Date: 28 April 2026

**Application by Fosse Green Energy Park Limited for an Order Granting Development Consent for the Fosse Green Energy Park Project.
Deadline 5 Submissions for Lincolnshire County Council (LCC)**

Comments on Deadline 4 documents

EN010154/APP/6.2.

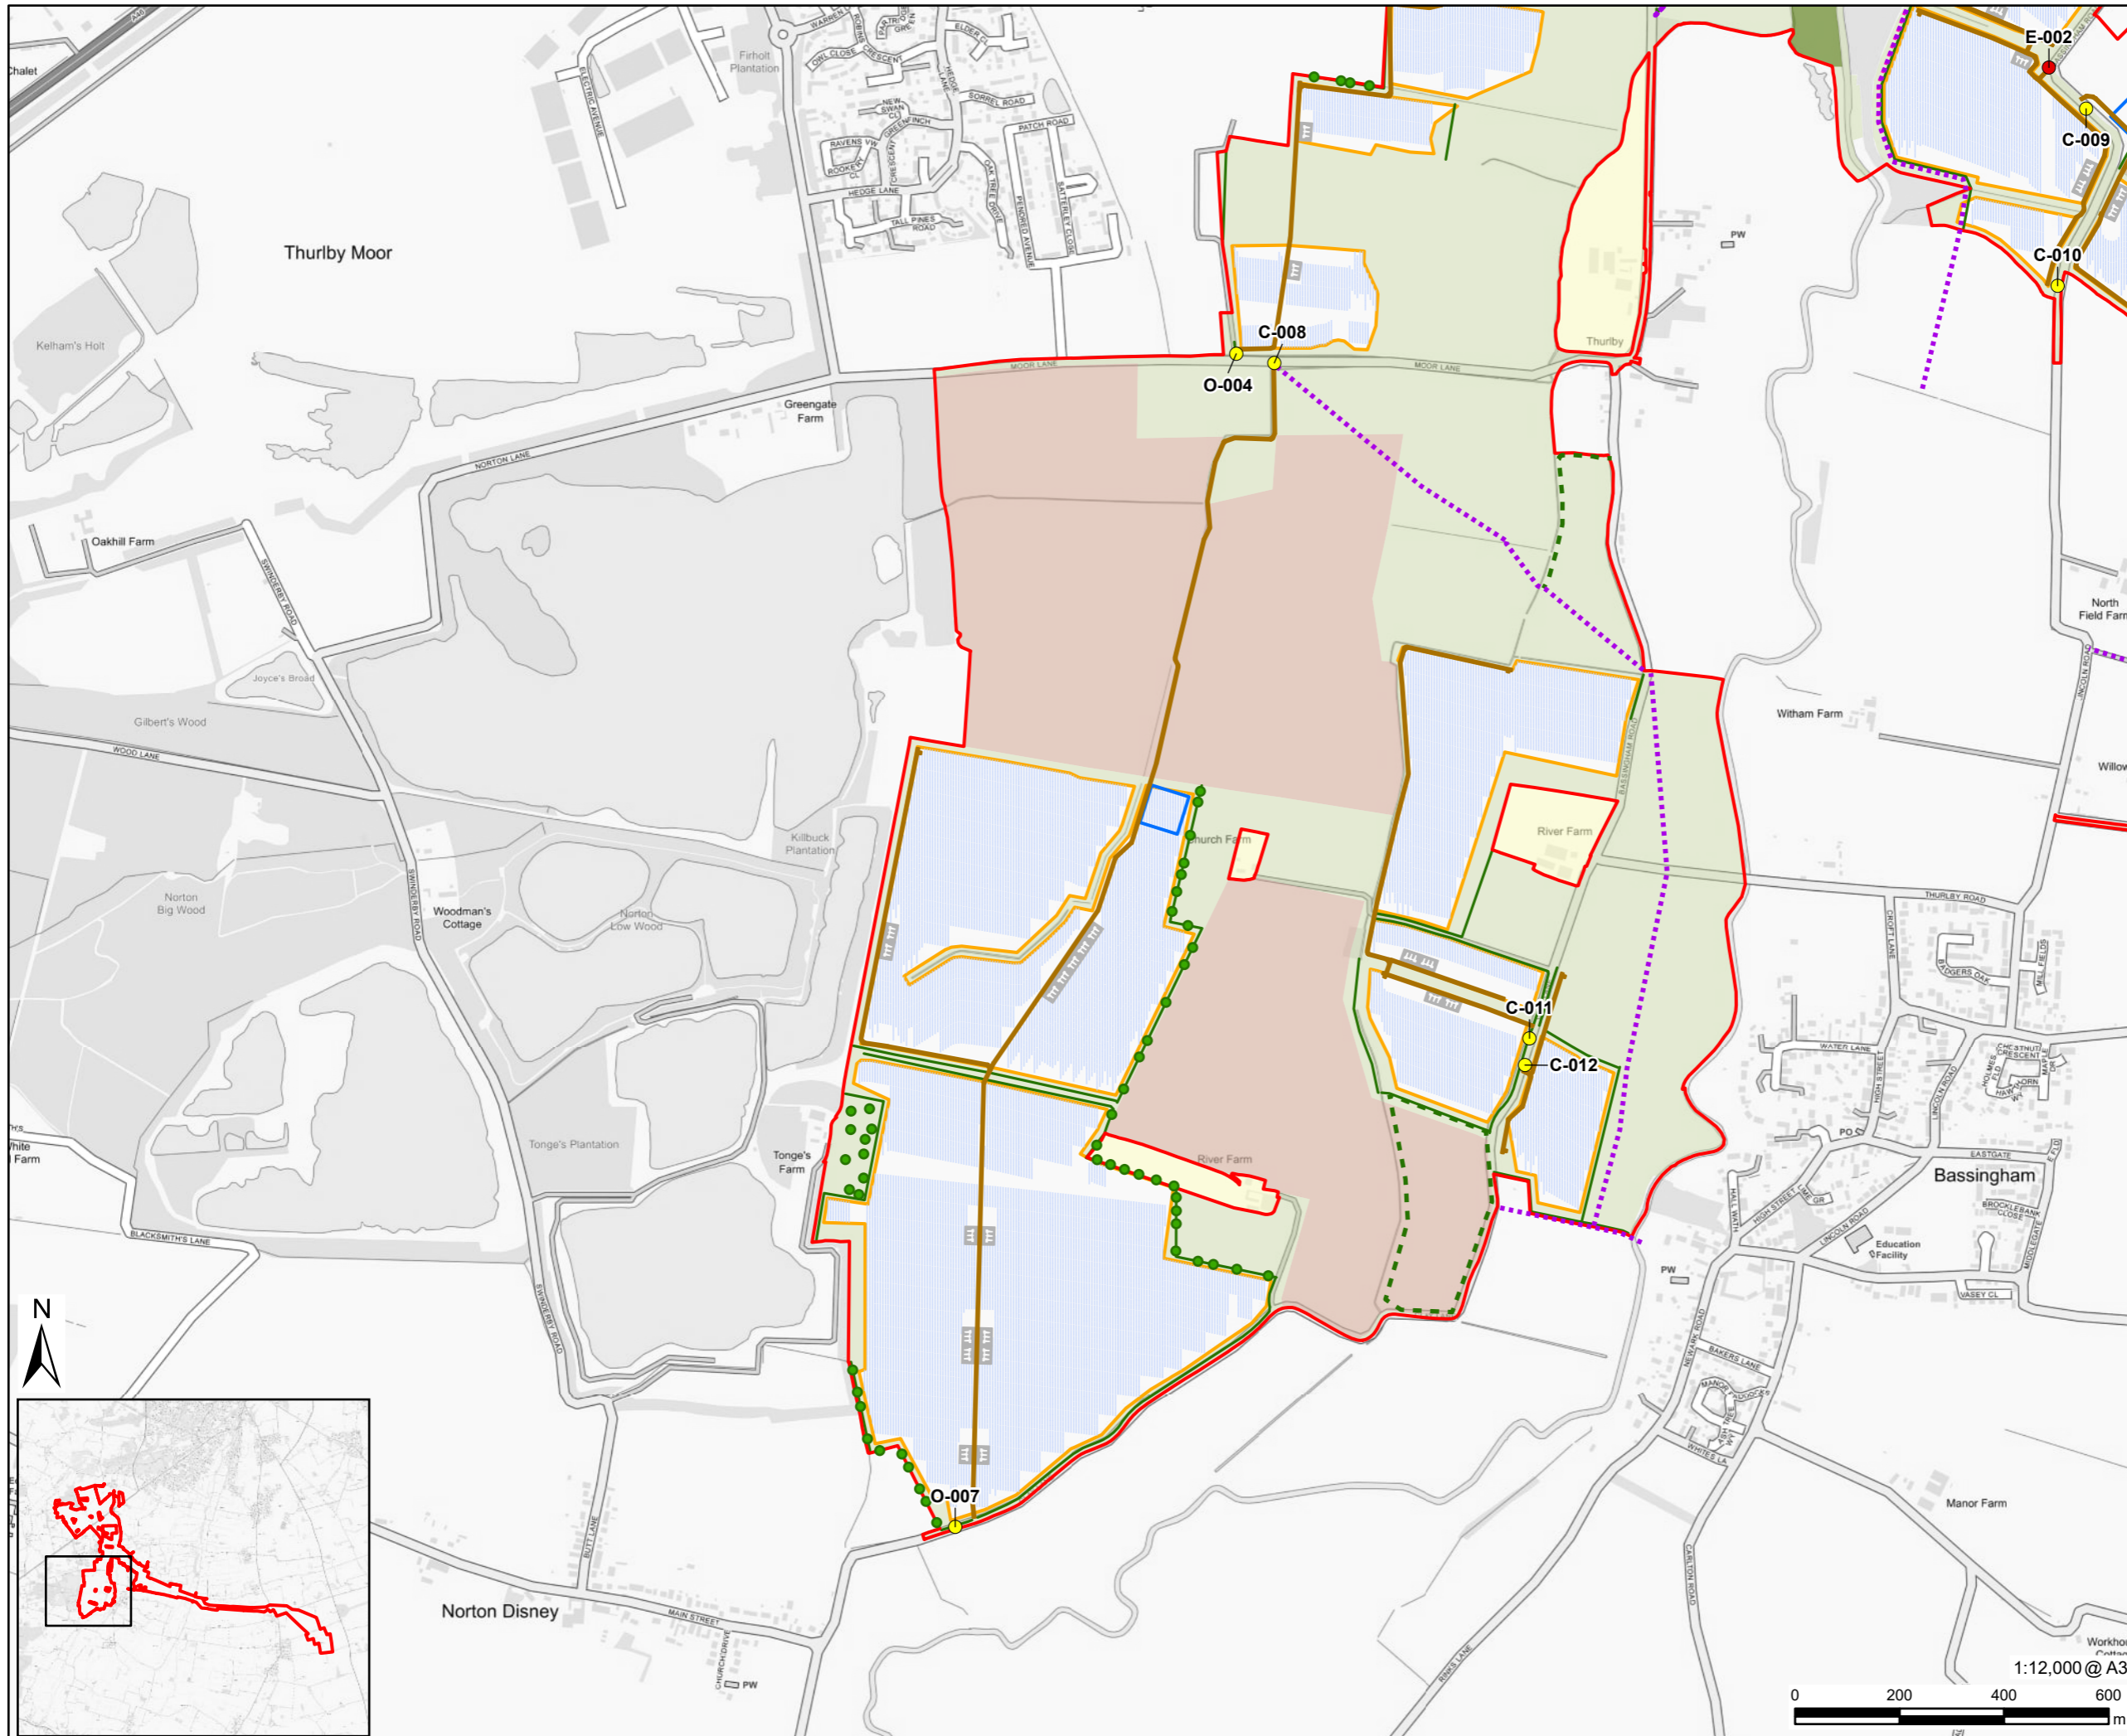
Site Layout Plan Revisions - Indicative Fixed South Facing Layout (Rev 3) and Indicative Single Axis Tracker Layout (Rev 3) [REP4-006 & REP4-007, respectively]

LCC assumes that the overall red line boundary remains unchanged, and thus LCC's previous comments in respect of minerals & waste safeguarding remain unchanged.
